From: Charlotte Burrows on behalf of Planning.Responses
Sent: 16 February 2018 09:50
To: Planning Scanning
Subject: FW: Proposed KFC at Fontwell - LPA ref WA/88/17

1. It would appear that there are proposed extension/changes planned for the Burger King. This is shown both on the Proposed General Arrangement Plan dwg 217052-A200 and also Proposed Site Layout Plan dwg 217052 A000.

drawing no. 217052 - A200 revision

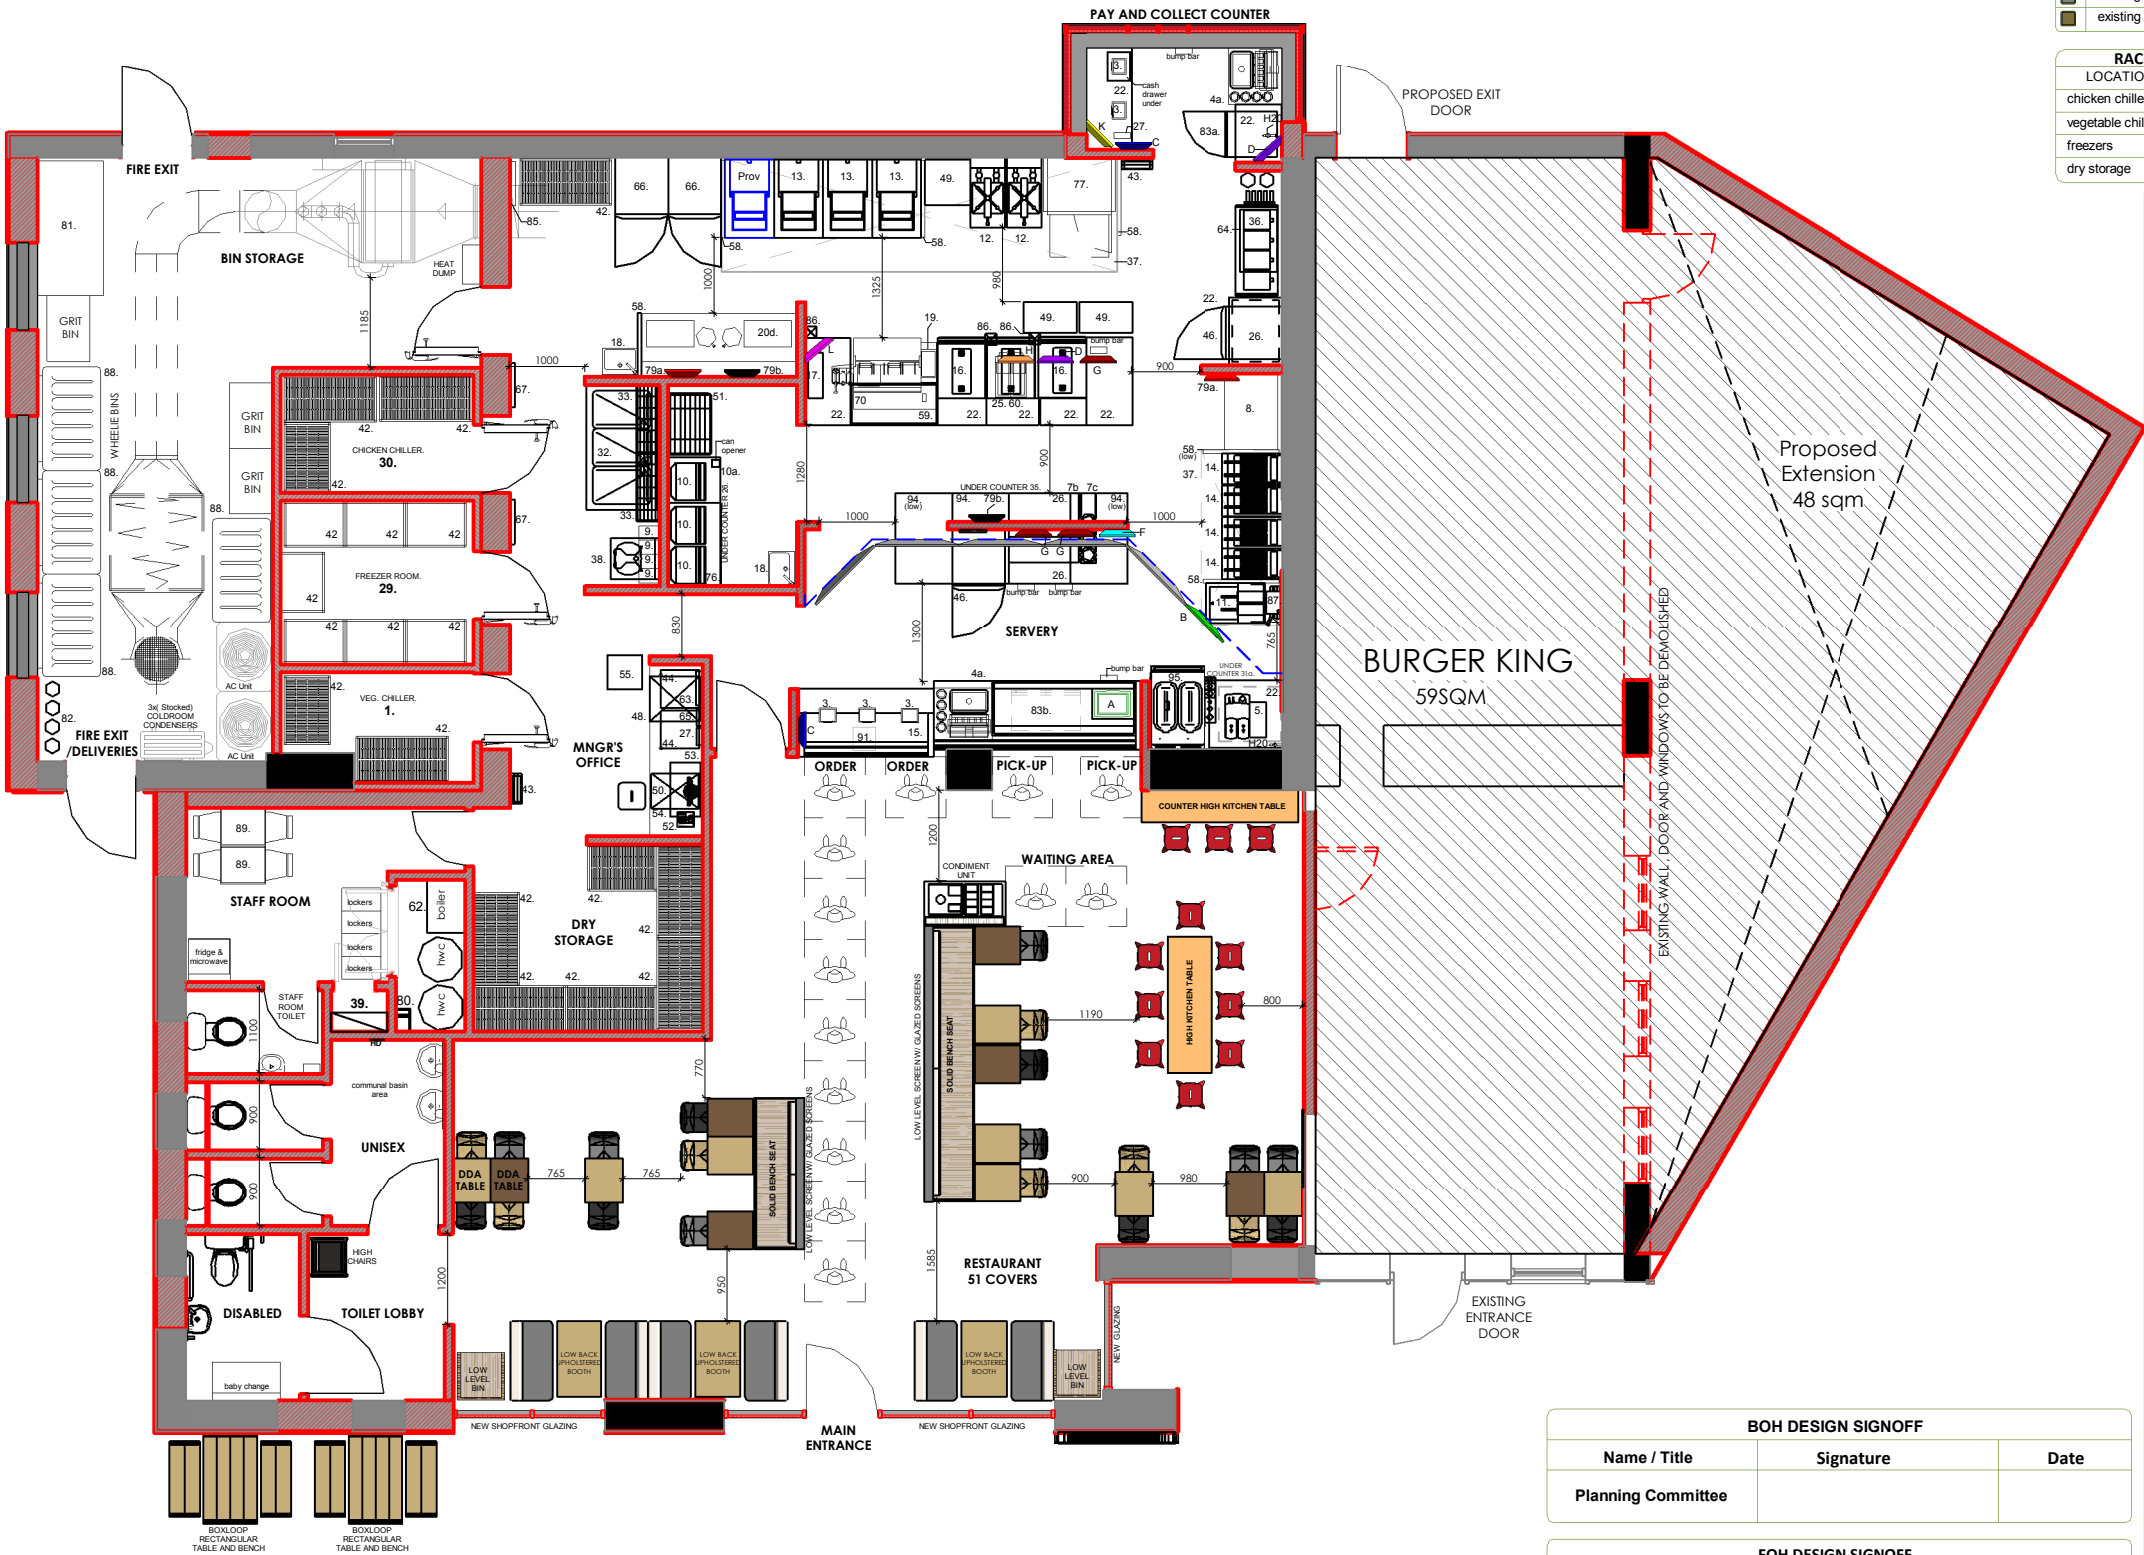
1. The application letter states "there are no proposed works to the attached Burger King unit" but the plans show a 48 sq m triangular extension. Which is correct? Is Burger King being extended or not?

4. Can the applicant confirm whether they consider the number of wash-hand-basins in the KFC kitchen to be sufficient (2 no.).

1. There are no external alterations or extensions proposed to Burger King. There may be an internal refit but no external changes are proposed
2. We would be happy to accept a condition restricting the hours of operation of the KFC and drive thru to 0700-2300. Would that be acceptable - my thoughts are that this would address EHO concerns on movements / noise and also comments raised by residents.
3. With regards the boundary with Travel Lodge - could boundary details / landscaping be conditioned?
